PLANNING CONSULTATION RESPONSE

Application No	2026/0548
Proposal	Renovation of existing sports pavilion, including the demolition of existing sports hall and erection of new single storey activity hall, new external terrace and steps.
Address	Carlton Park, Church Street, Carlton, Barnsley, S71 3HG
Date of Consultation Reply	05/08/2026
Consultee	Katie Lawrence, Planning Ecologist

drawing N°	250704-025.02	status	Planning
------------	---------------	--------	----------

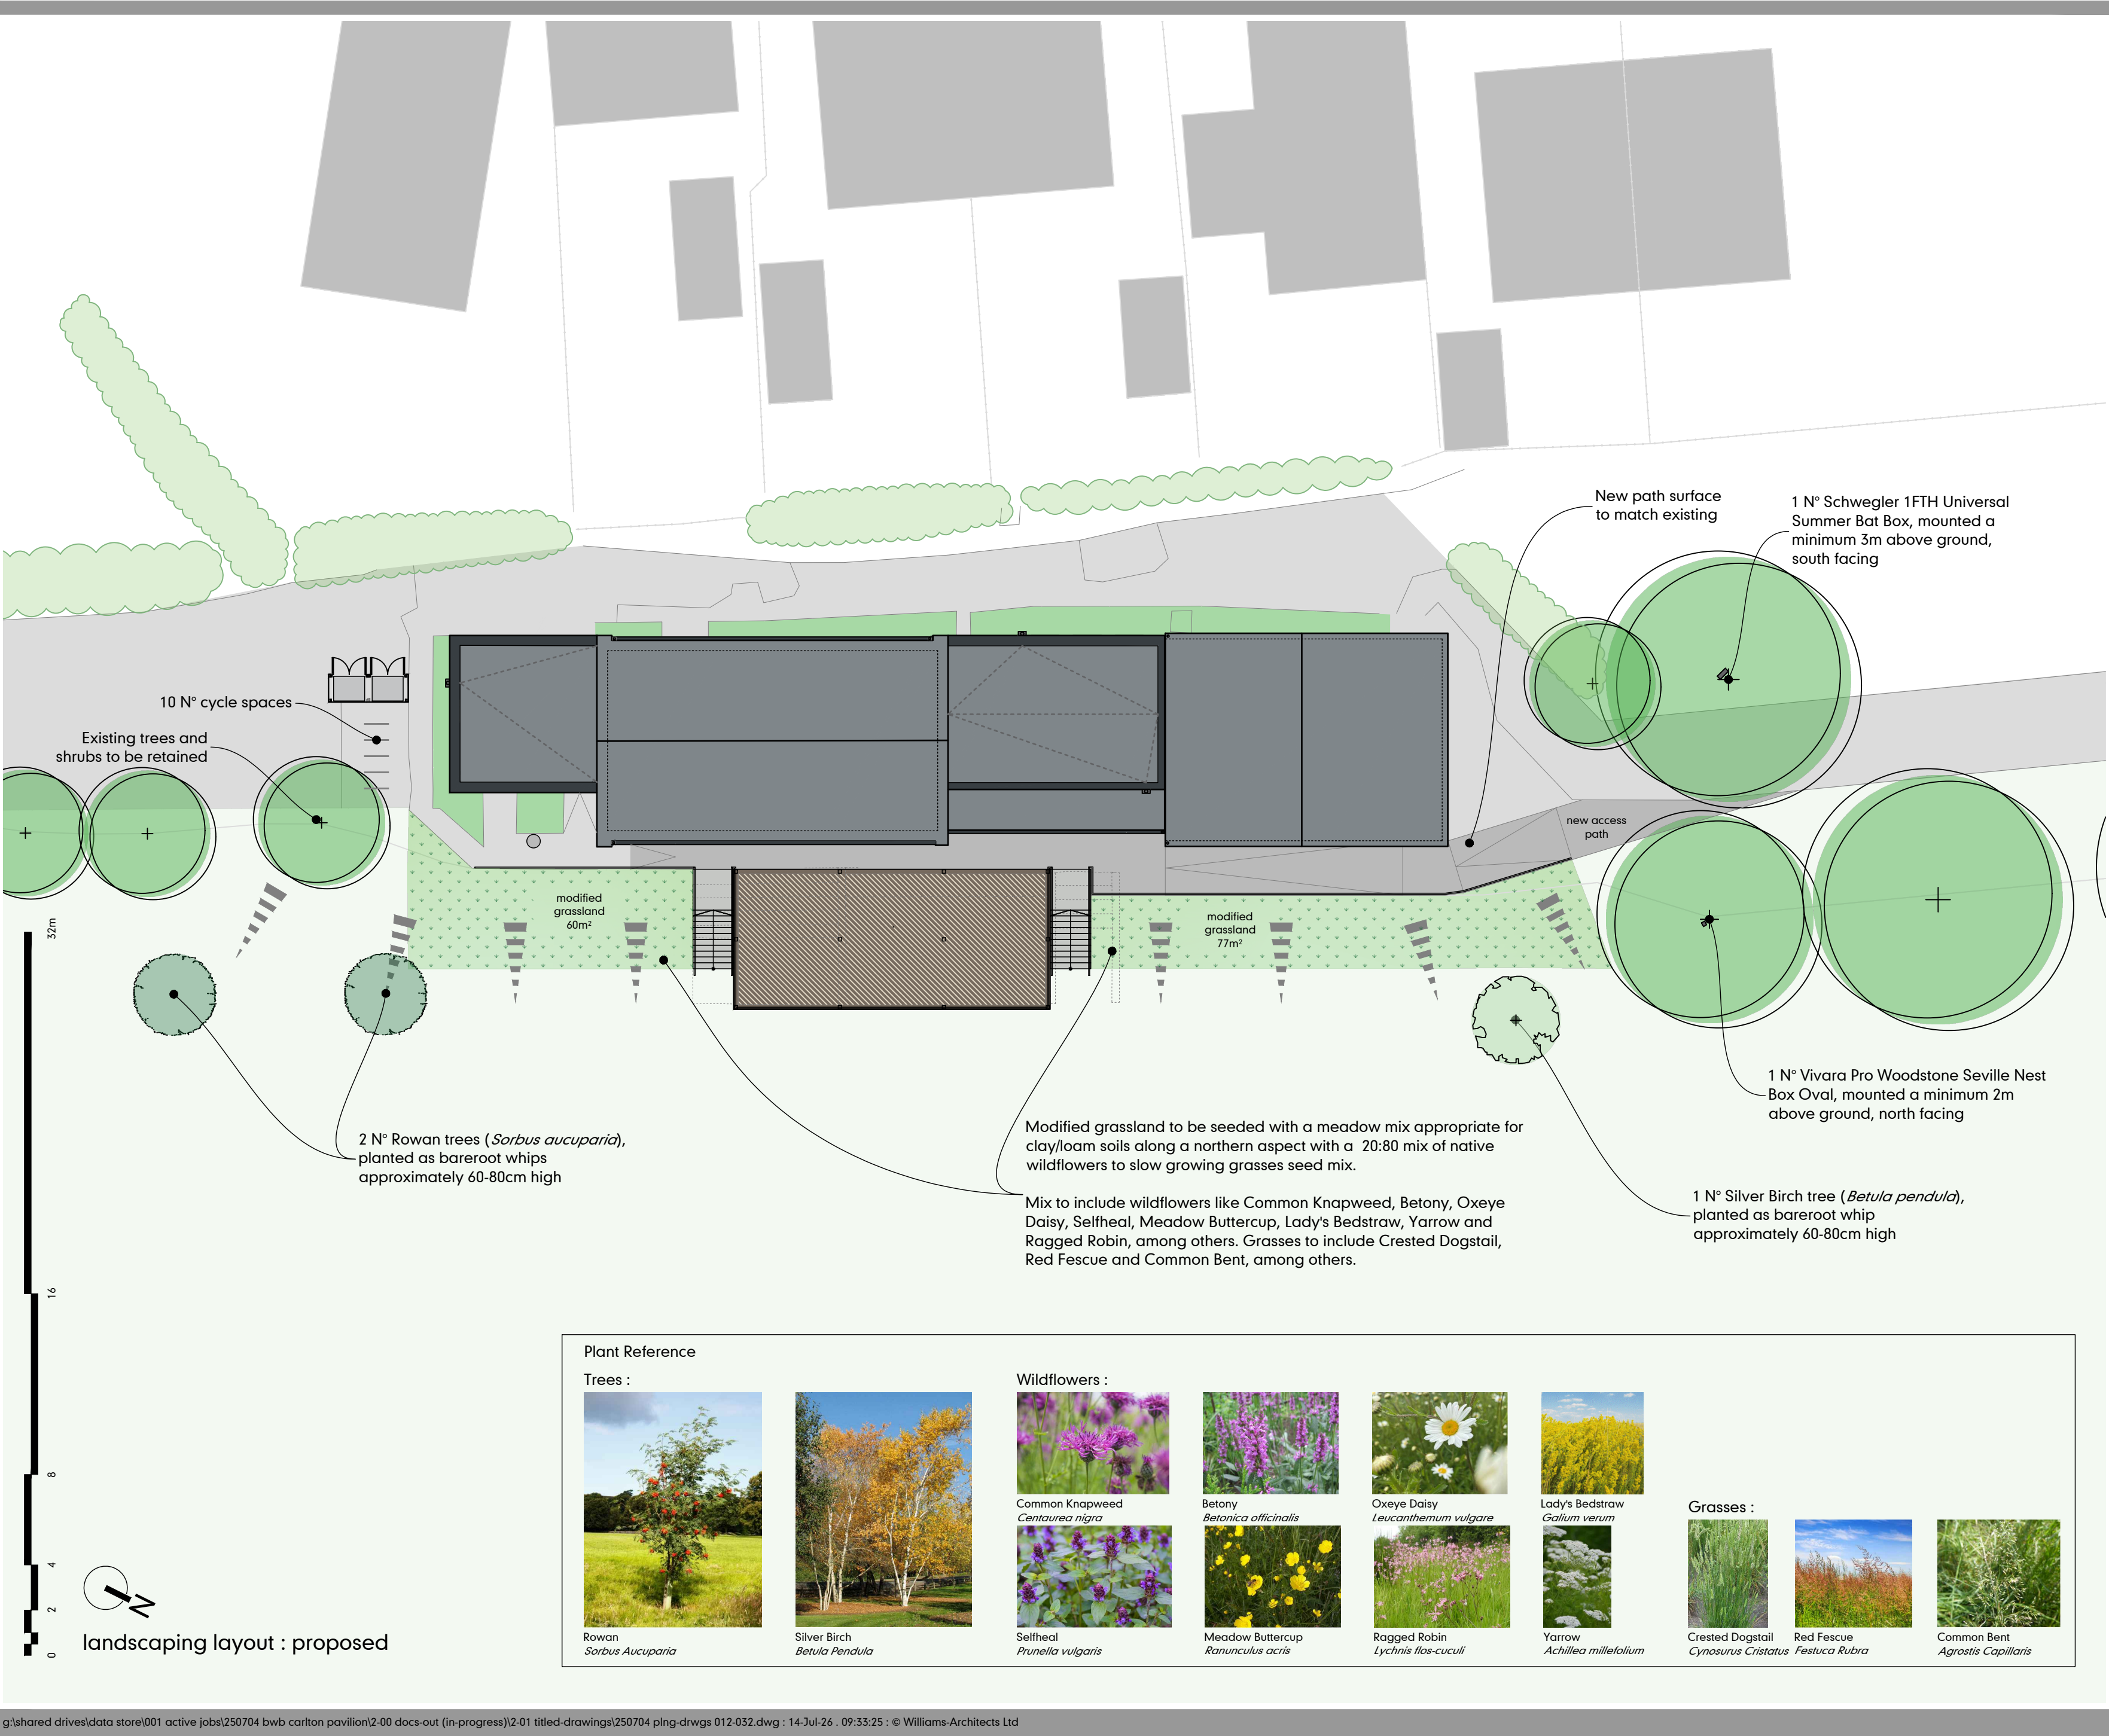
- Recommendations have been made for precautionary works in relation to nesting birds and the provision of bird and bat boxes as part of the proposed building works or on retained trees, which is welcomed. The proposed landscaping layout plan (drawing no. 250704-025.02) shows a bat and bird box installed on trees within the site. These measures can be secured by a planning condition.

- The EclA includes information on proposed post-development habitats which are accounted for within the metric submitted. The post-development table sets out that there will be 4 new trees proposed as part of the proposed landscaping; however, when referring to the proposed landscaping layout plan (drawing no. 250704-025.02) it appears that only 3 new trees are being proposed. This should be checked and amendments made where necessary. Currently the metric indicates a gain of 0.036 habitat units (14.78%); however, this is based on the planting of four trees rather than three, which may affect the results of the BNG calculation.
